**PINS ref: EN010170**

**Application by Green Hill Solar Farm Ltd. for an Order granting Development Consent for a proposed solar development on land between Northampton and Wellingborough**

**CPRE Northamptonshire  
Written Representation  
November 2025**

Title:
Figure 13.15: Access Locations for Sites and
Cable Route Corridor (South Area Part 1)

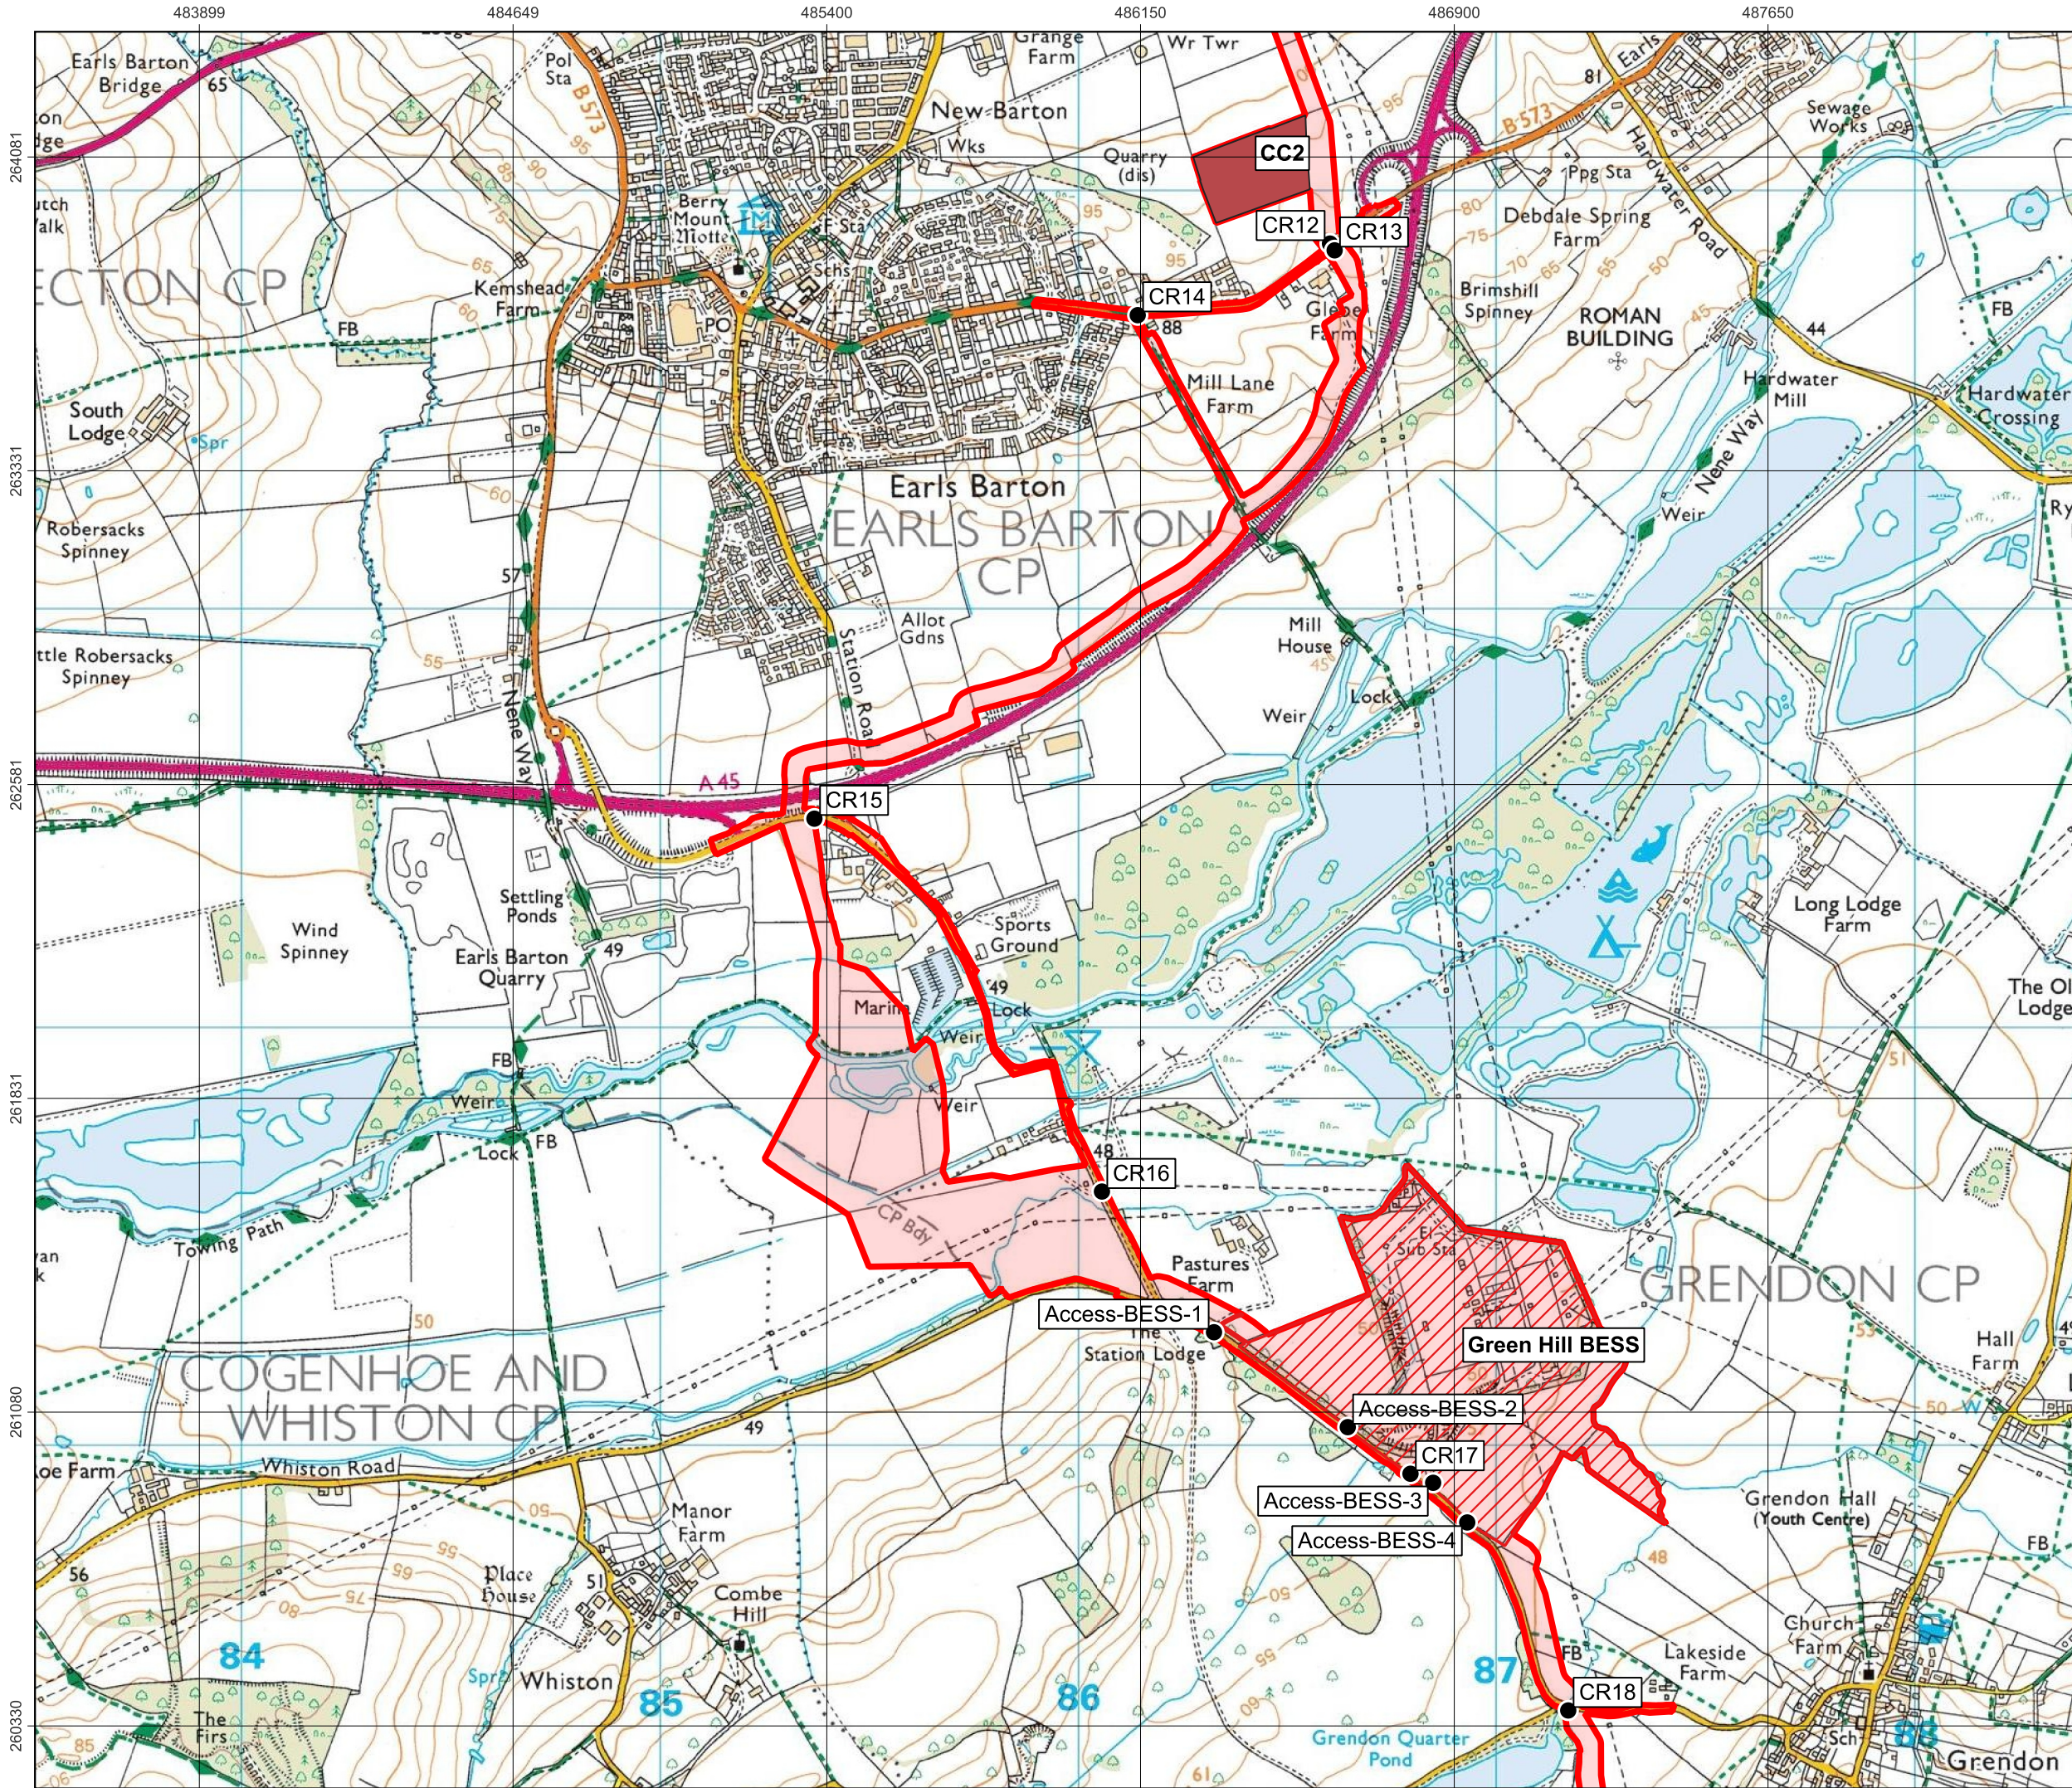
In our PIER response we expressed the view that traffic should not pass through villages. At ISH1 the applicant admitted that Access F.2 is connected by an internal track to Access F.3 meaning that it is not necessary to use Link 81. We therefore feel that the use of this High sensitivity route cannot be justified and should be deleted from the scheme.
